From: Sarah Burrow
Sent: 04 May 2022 11:55
To: Amber Willard
Cc: Planning.Responses
Subject: RE: Planning Consultation on: BN/28/22/DOC

Engineers Comments Regarding Surface Water Drainage

Application No: BN/28/22/DOC
Registered: 10th March 2022
Site Address: Land the rear of Highground House and Orchard End Barnham
Description of Works: Approval of details reserved by condition imposed under BN/114/21/PL relating to conditions 3-schedule of materials and finishes, 4-renewable energy, 6-Construction Management Plan, 8-bin storage, 10-covered and secure cycle parking spaces, 11-electric vehicle charging points, 12-surface water drainage, 14-foul water drainage and 17-external lighting.

DRAWING TITLE
DRAINAGE LAYOUT

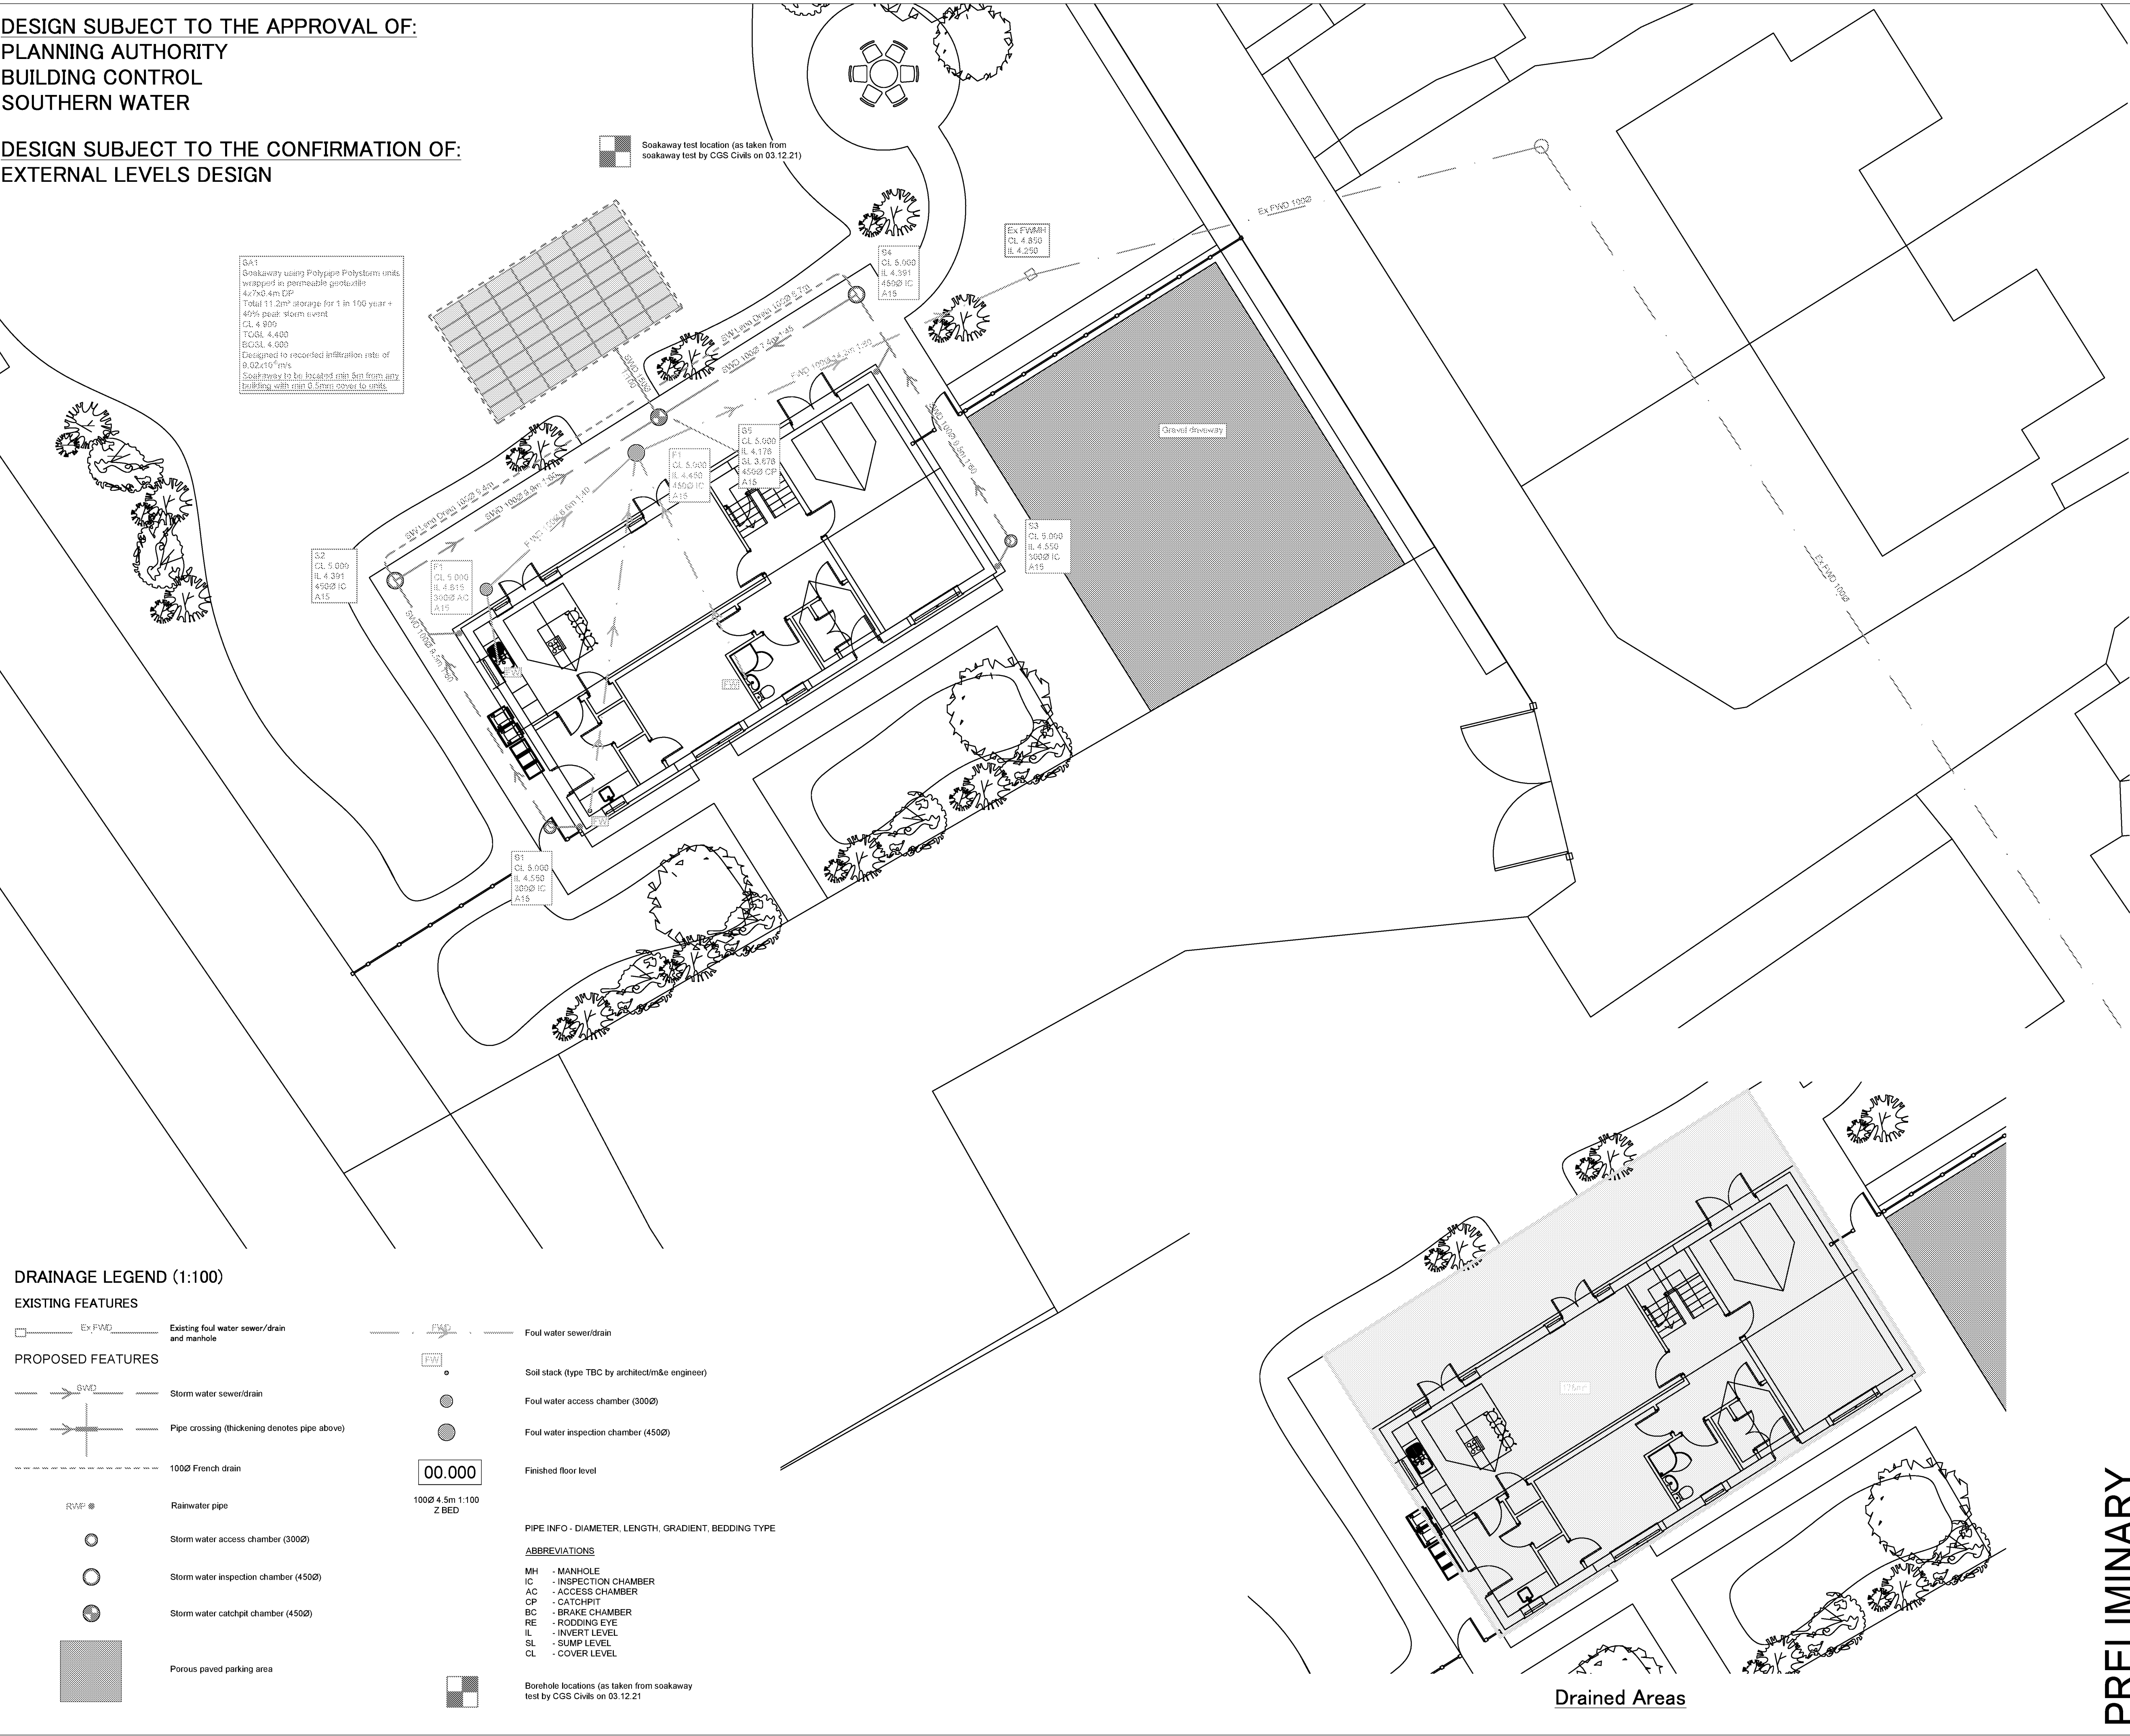
One minor alteration is requested before I recommend discharge of said condition; please can the invert level of the incoming pipe to the soakaway be shown on the drainage layout. At present it could easily be misunderstood to be laid at the base of the soakaway and it needs to be at least 74mm from the base (above the 1 in 10 +40% level).

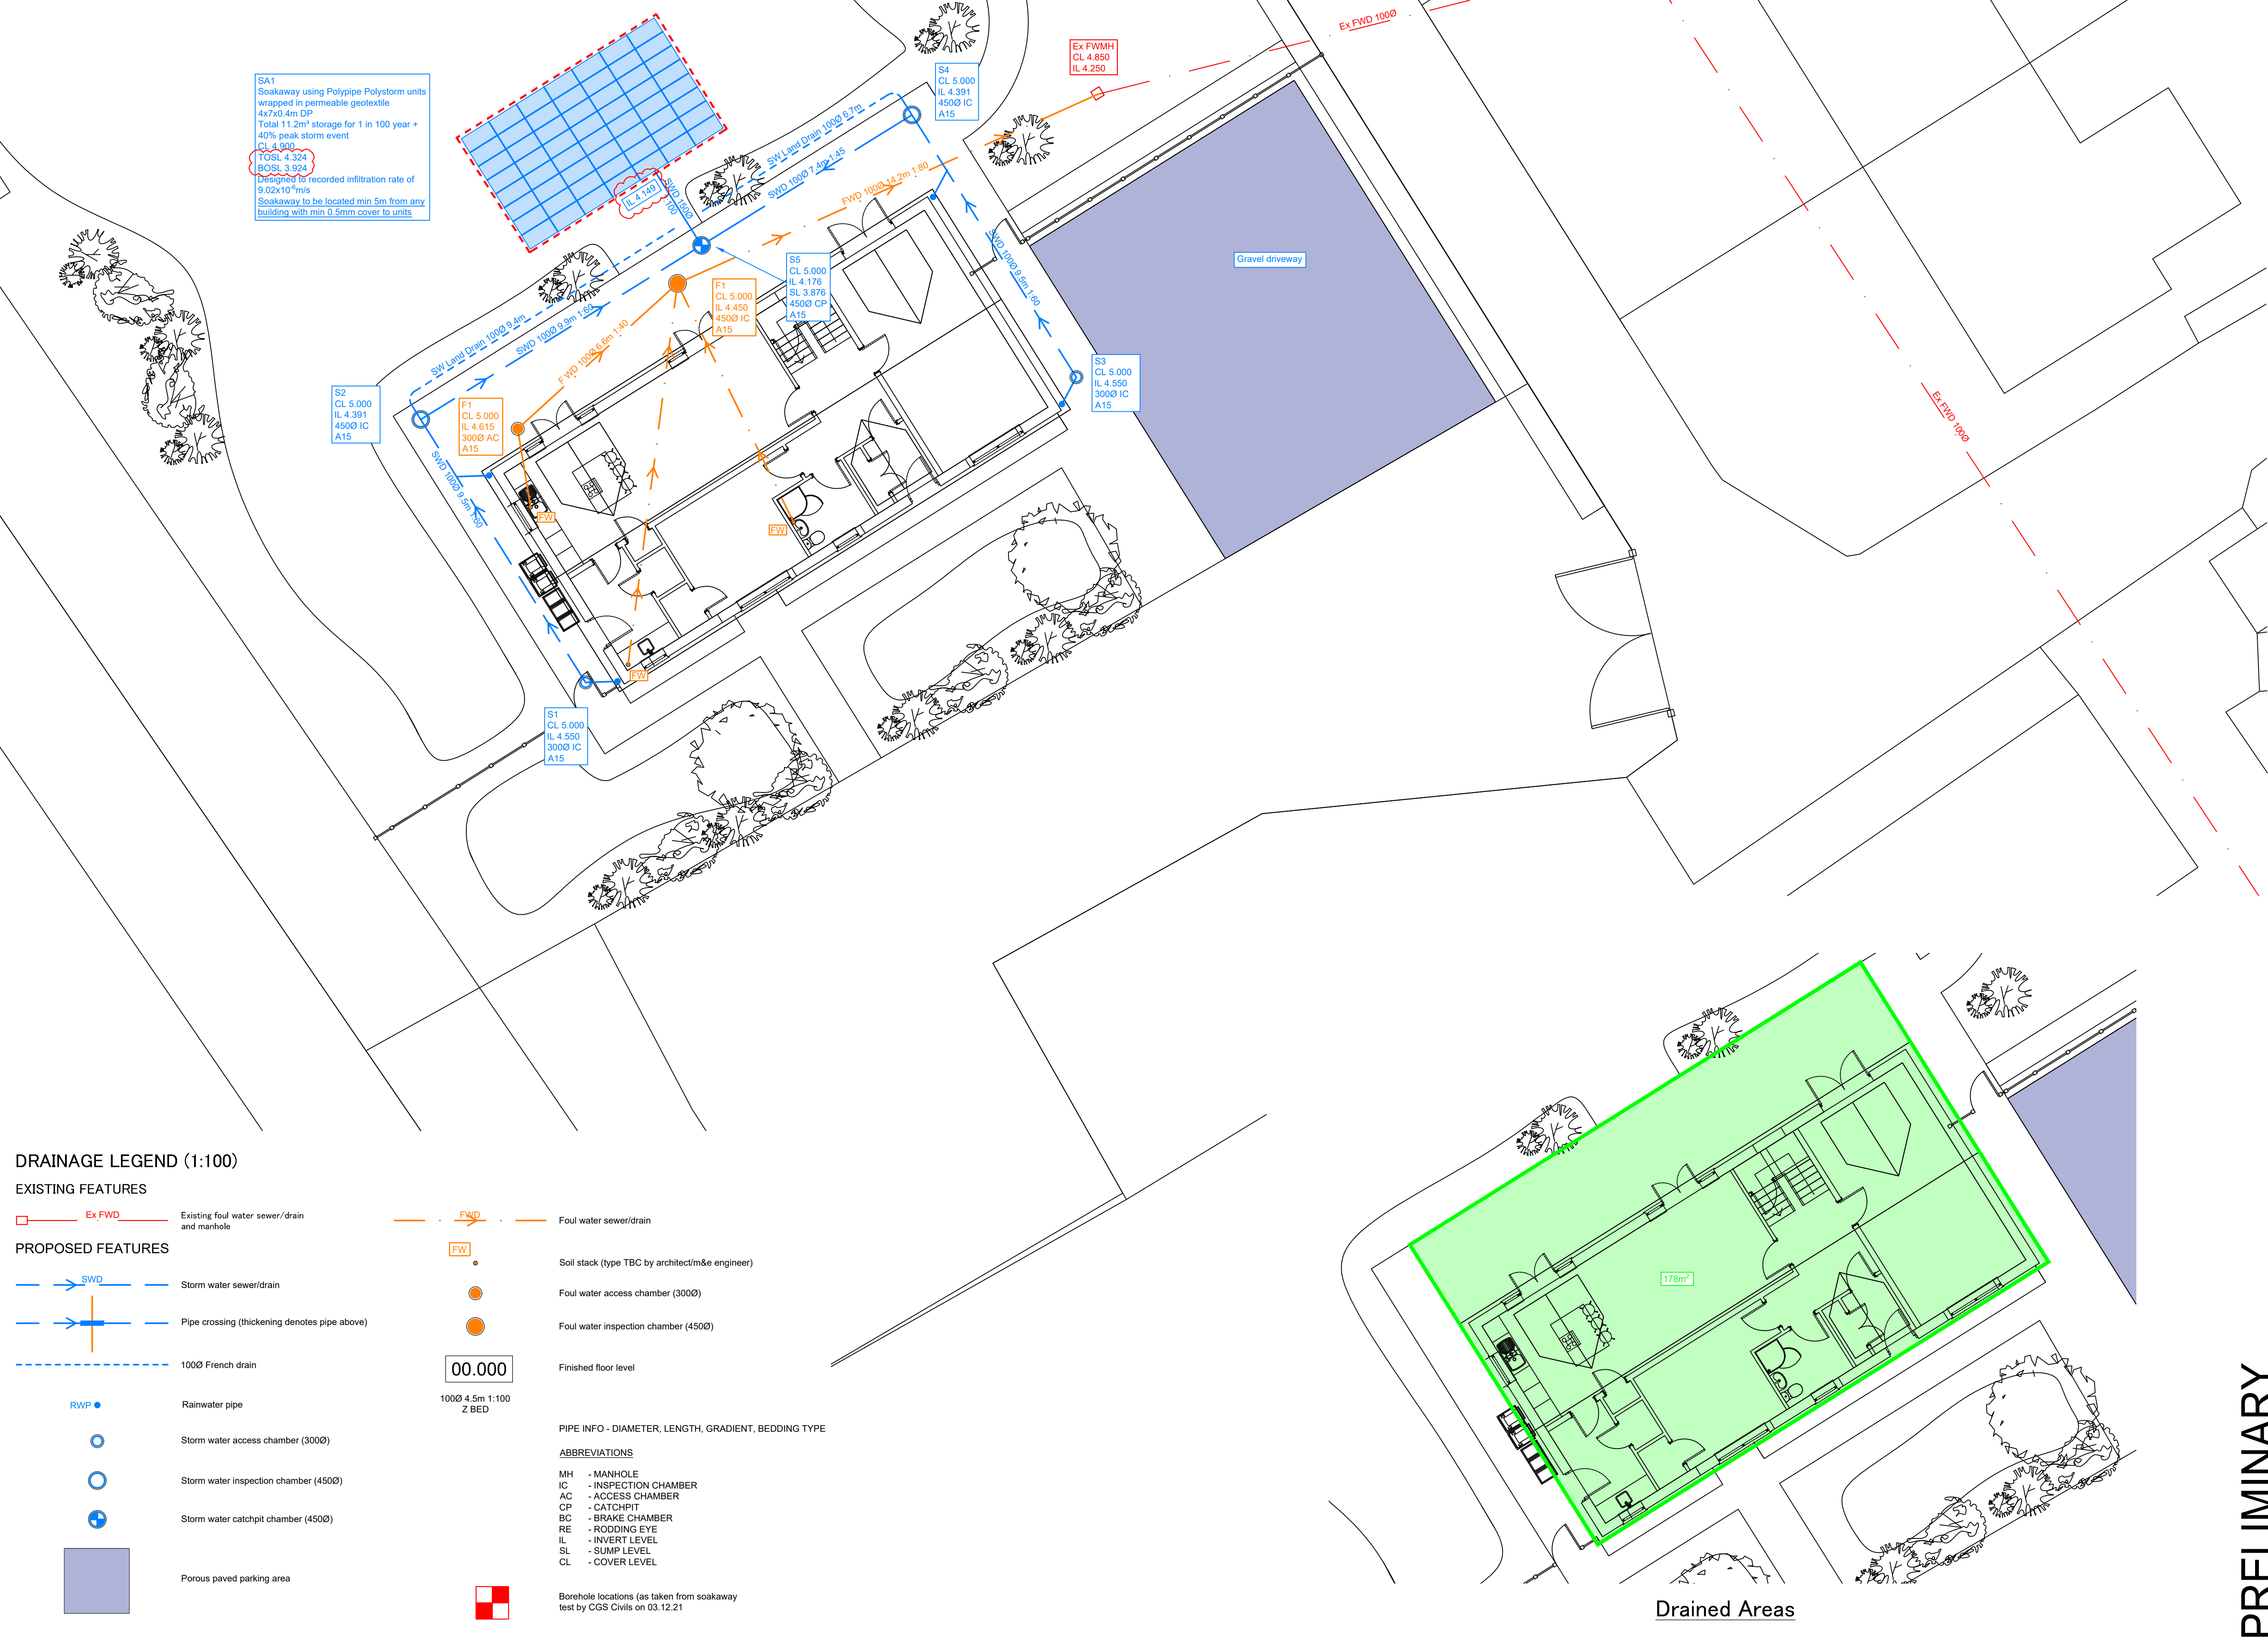
I attach the plan above. Hopefully this is address your comment below

My apologies, I must've missed the request. The new plan is fine and I recommend that the condition is discharged.

- Drainage Layout C1931 P 100 P1
- Drainage Details C1931 P 200 P- (In surface water drainage report)
